From: Giles Dixon [REDACTED]
Sent: 17 August 2017 15:57
To: Anita Gardner
Subject: Re: AB/103/17/PL Former reception building.

> Subject: AB/103/17/PL Former reception building.

drawing title:
Site Layout – Plots 3&4

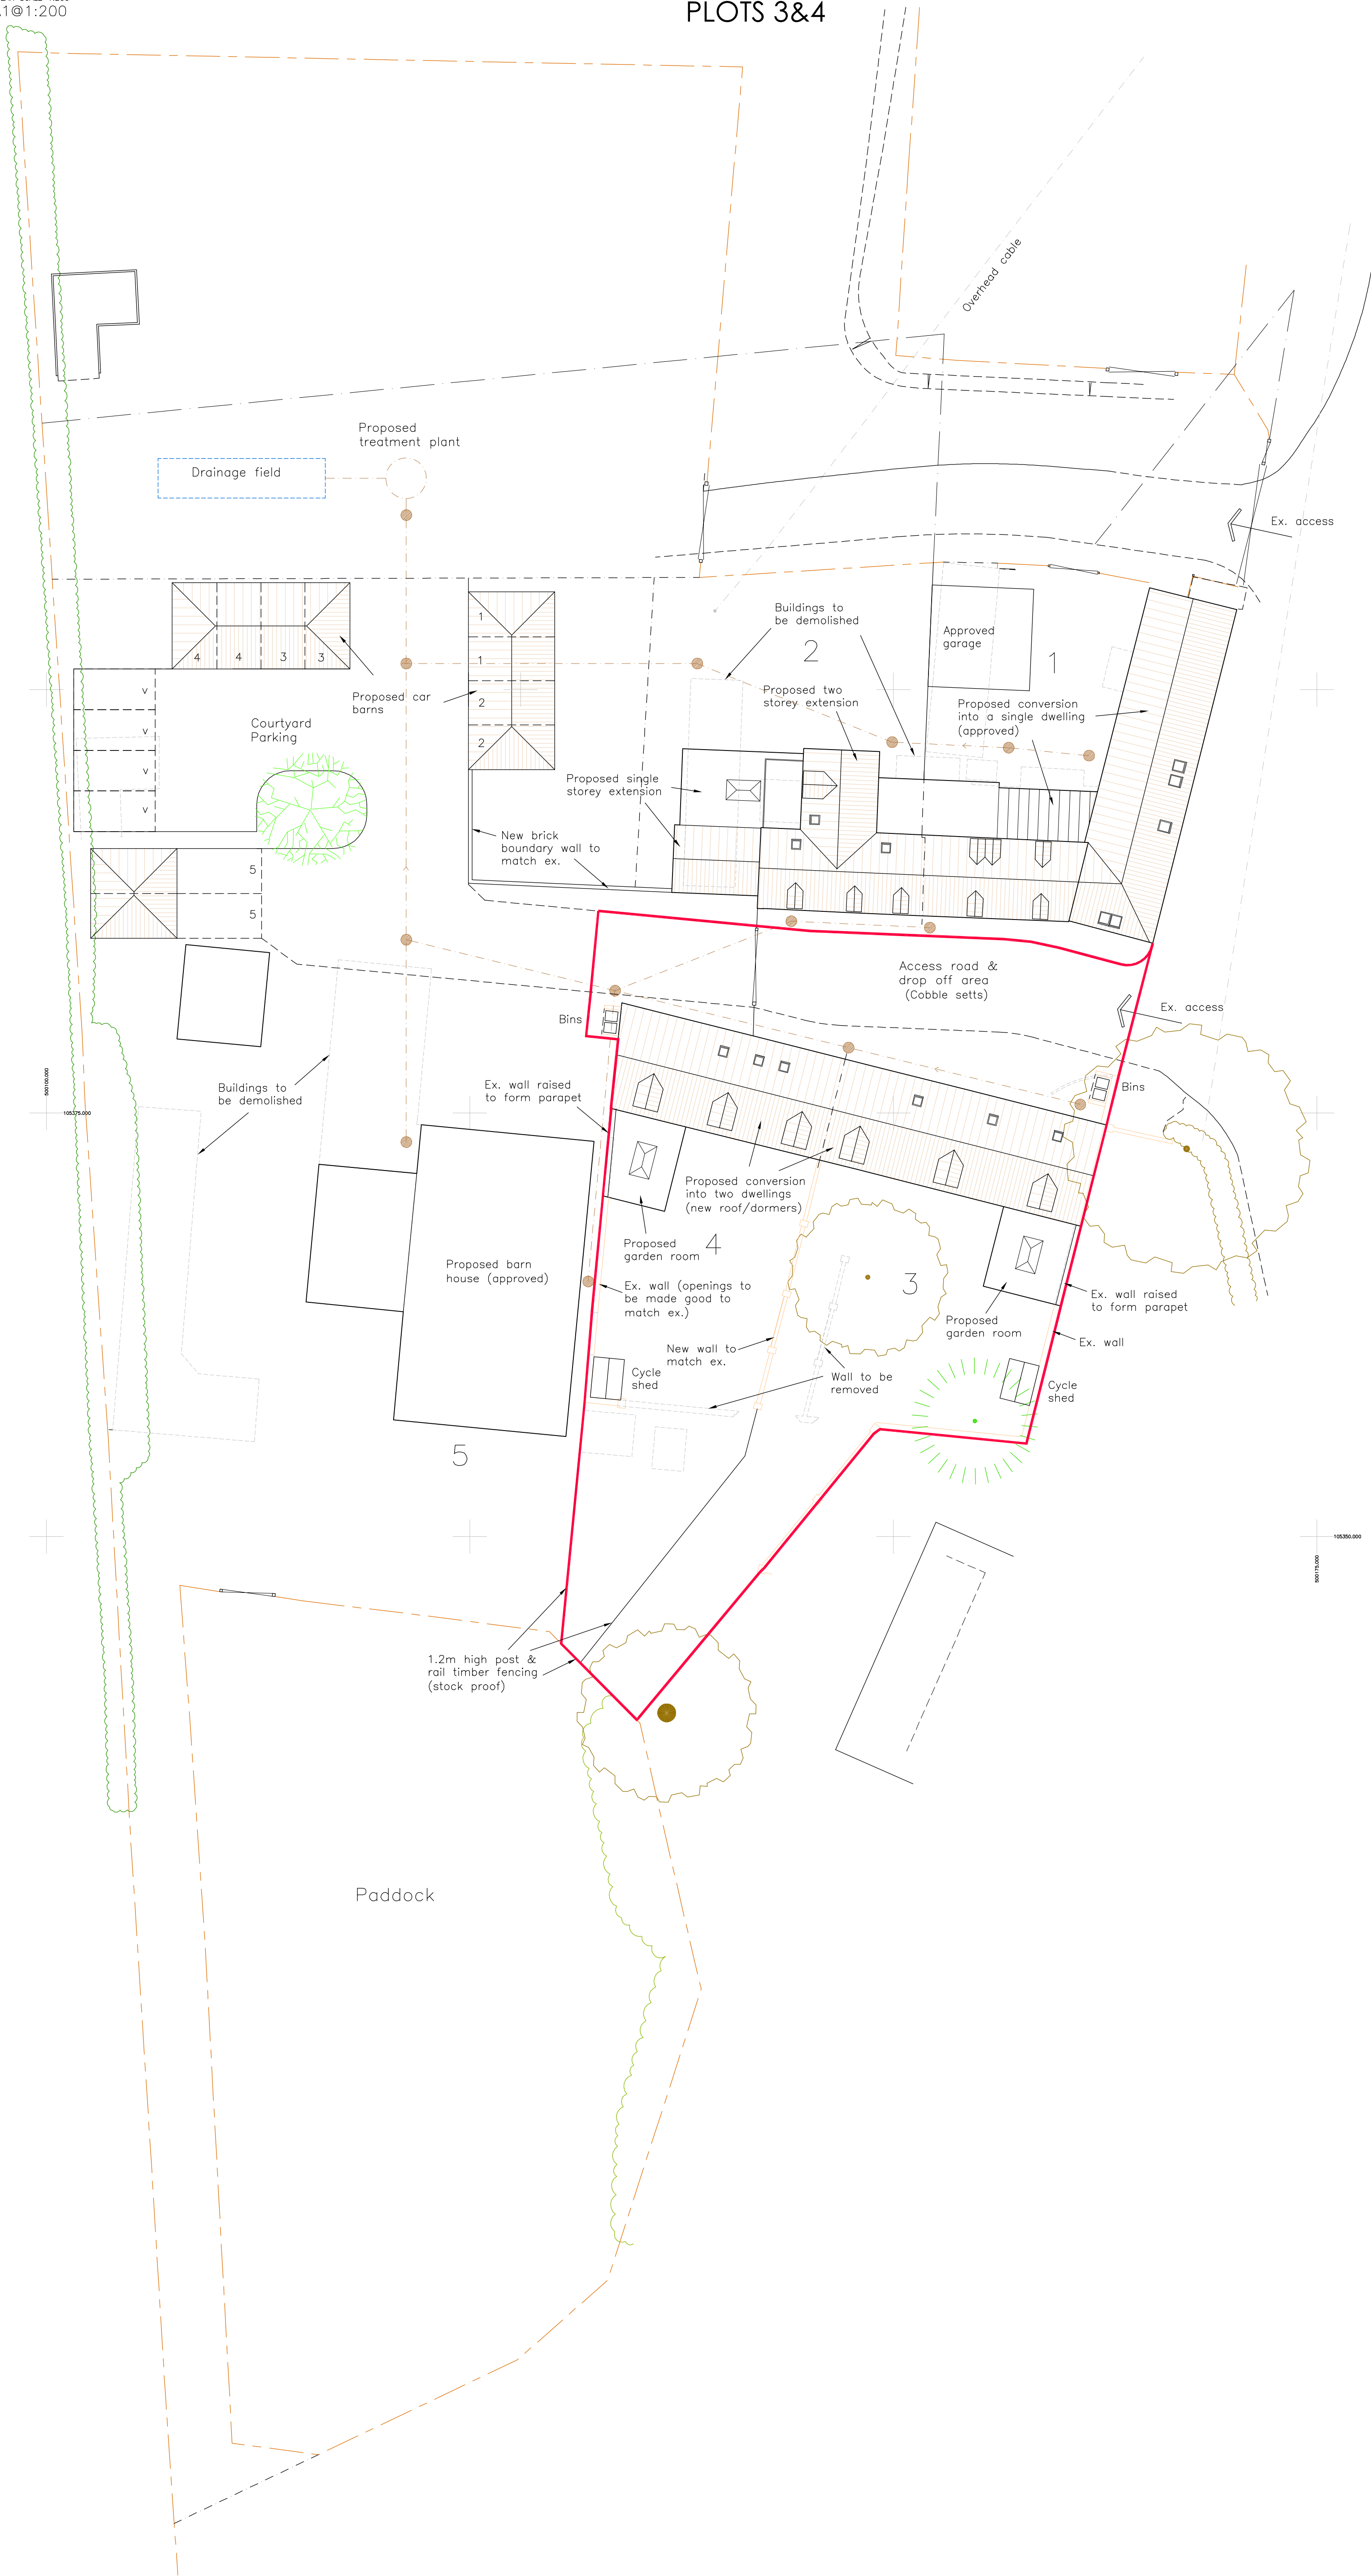
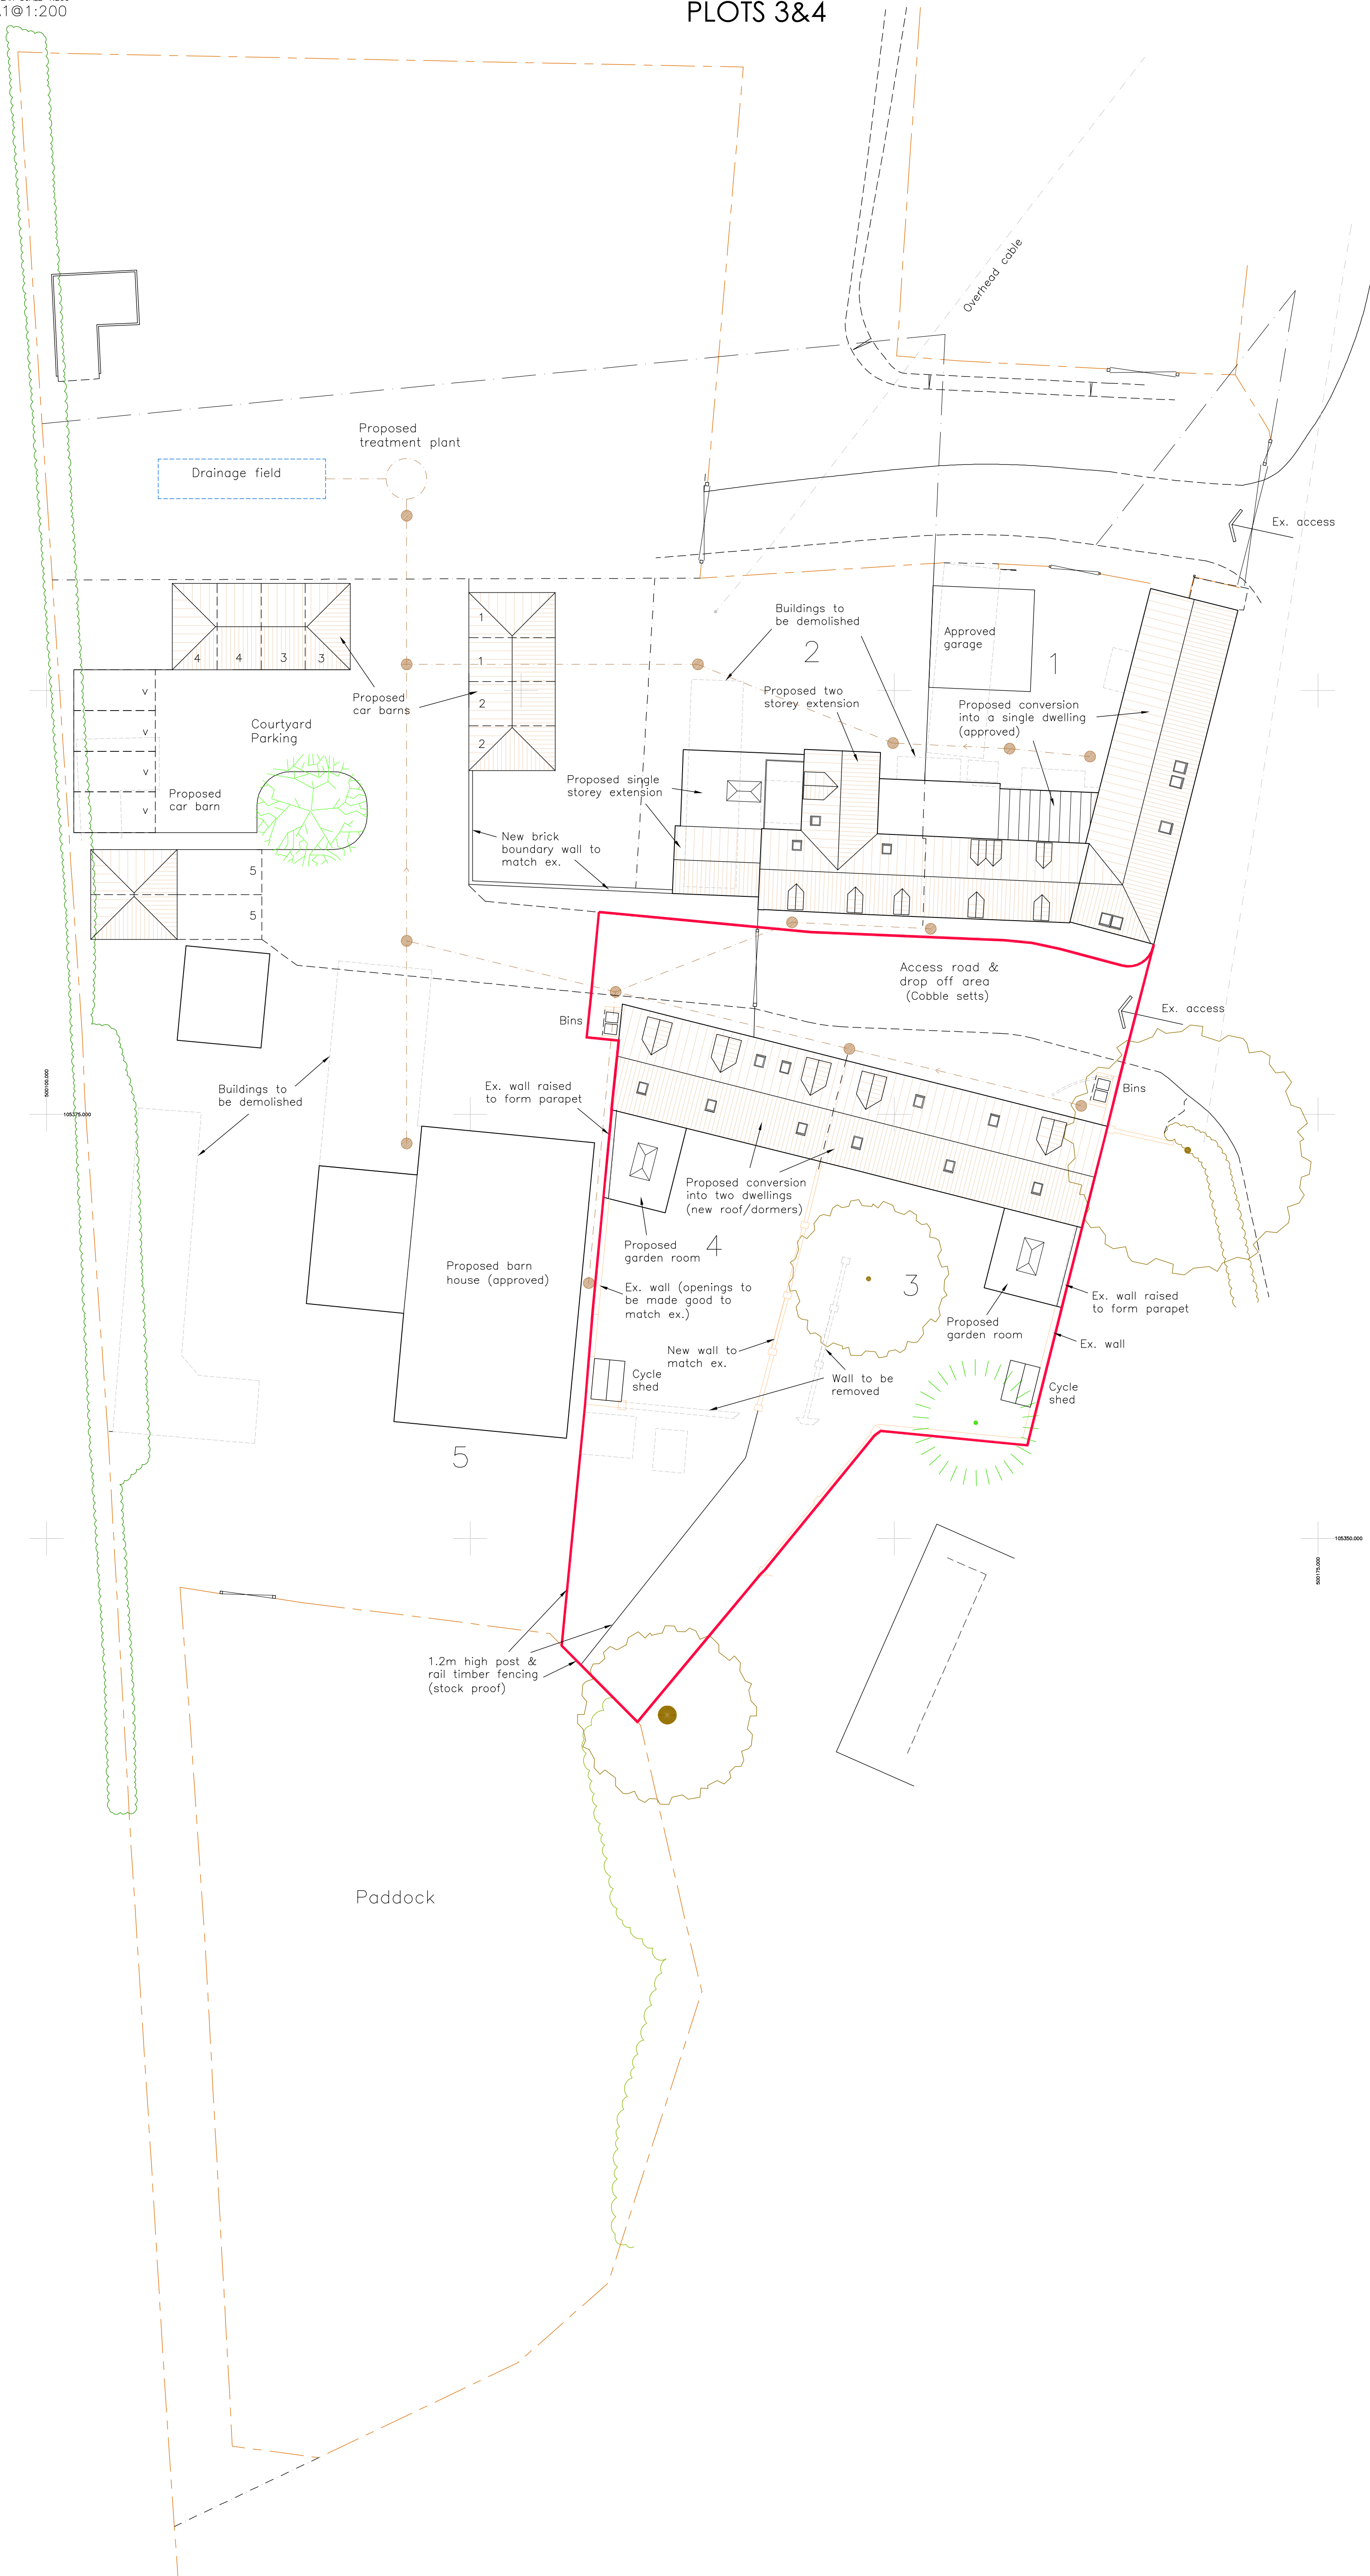
> I will arrange for the plans to be substituted. Drawing P301 the Site Layout Plan will also need to be amended.
